**From:** Tom [REDACTED]  
**Sent:** 29 March 2021 22:04  
**To:** Nicola Moore  
**Subject:** AW/104/21/PL - Proposed works at 97 Aldwick Road Aldwick PO21 2NY  
**Attachments:** D.1091-06 rev A Proposed Plans.pdf; CIL Form - 97 Aldwick Road - March 2021.pdf

Drawing No.	Date:
D.1091 - 06	04-03-21
Rev.	Date:
A	27-03-21

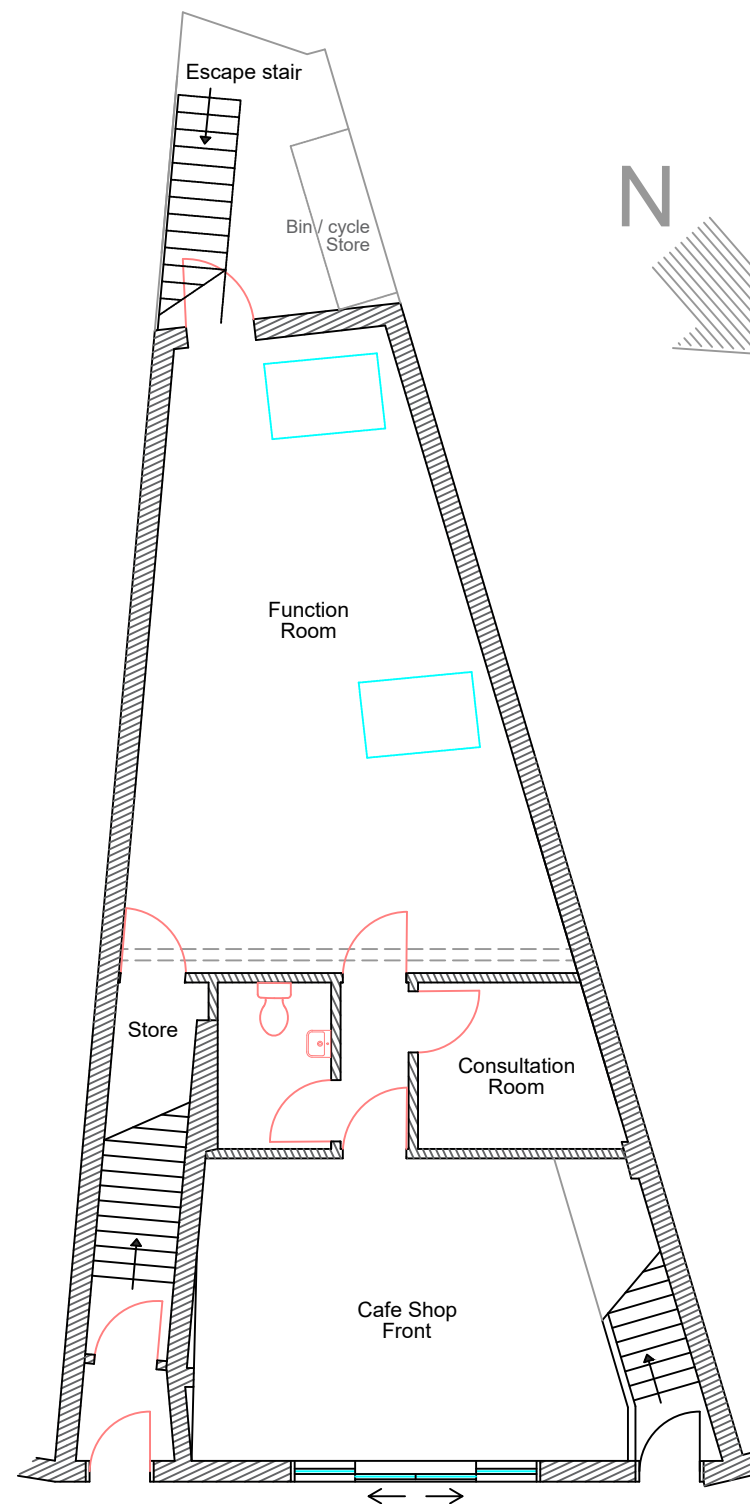
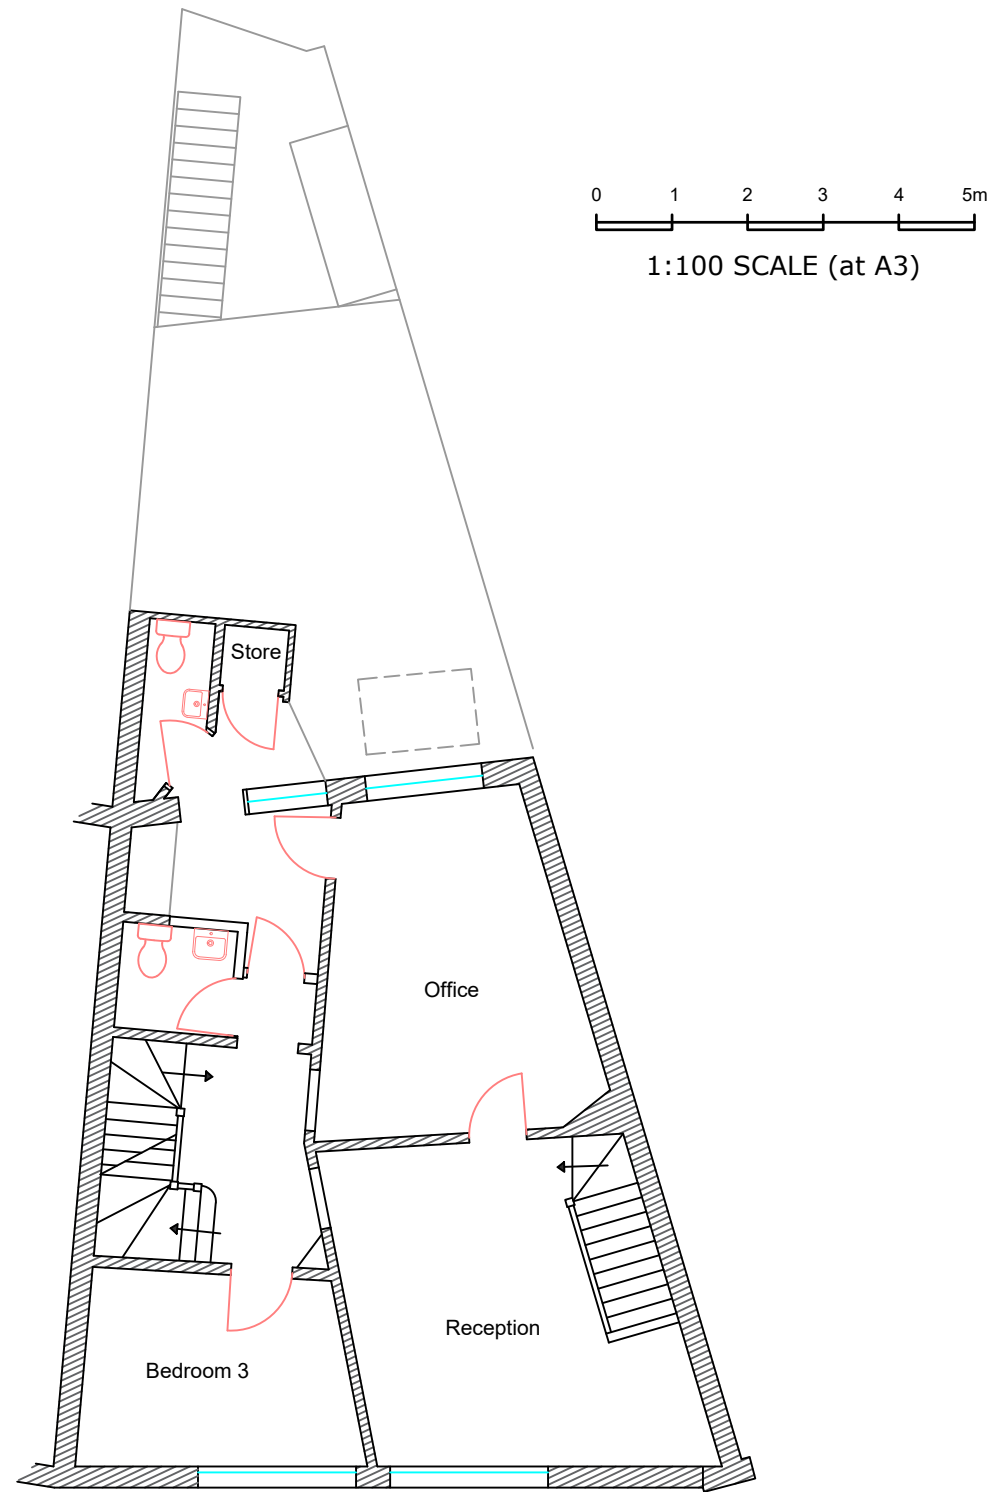
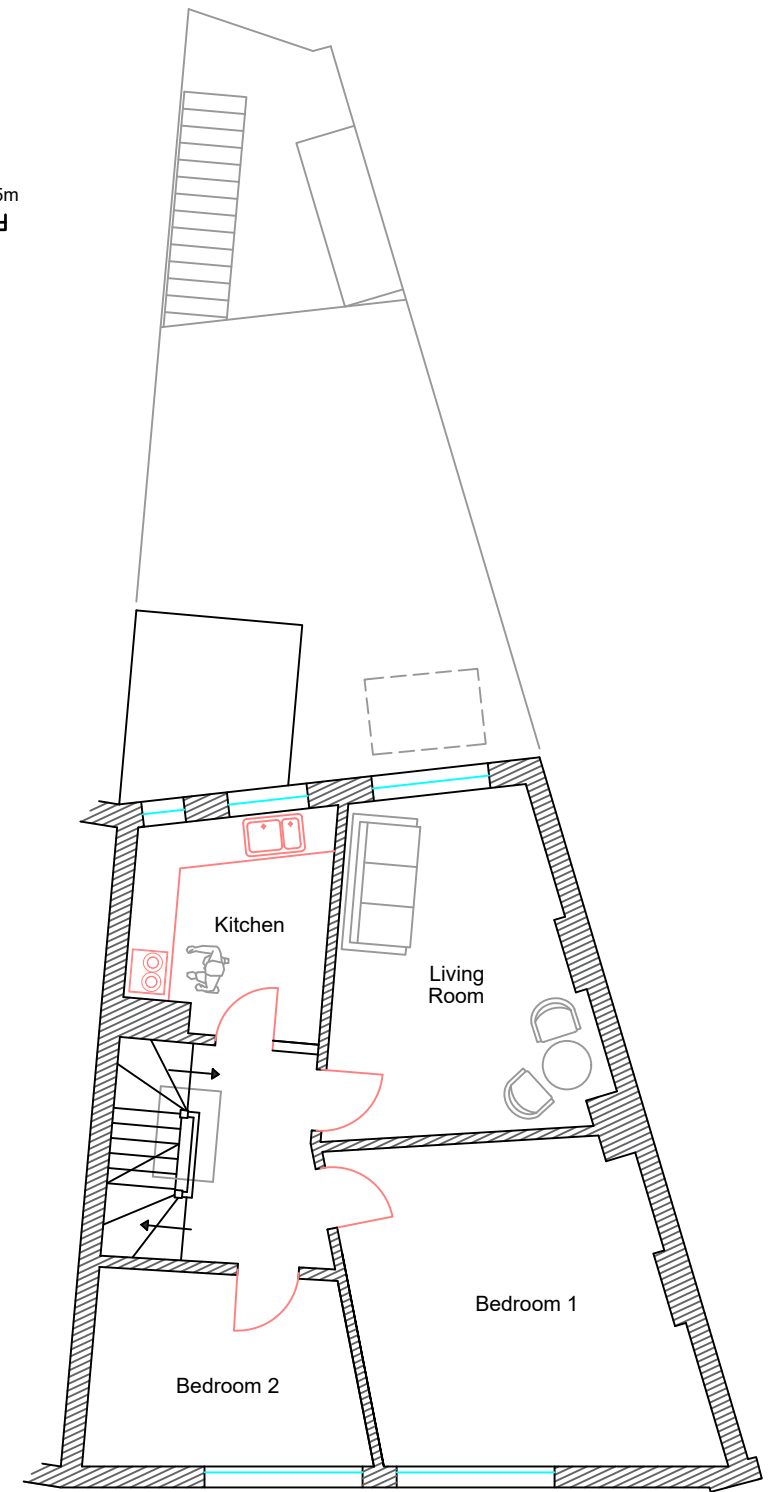
The proposed floor plans show 2 x Bedroom 2, please amend accordingly and re submit CIL Additional Information Form

My apologies, Please find attached a revised drawing which shows Bedroom 3 not Bedroom 2. The proposed development does not increase the number of bedrooms compared to existing and the residential floor area is also the same (slightly less). Please see attached the CIL Form as requested.
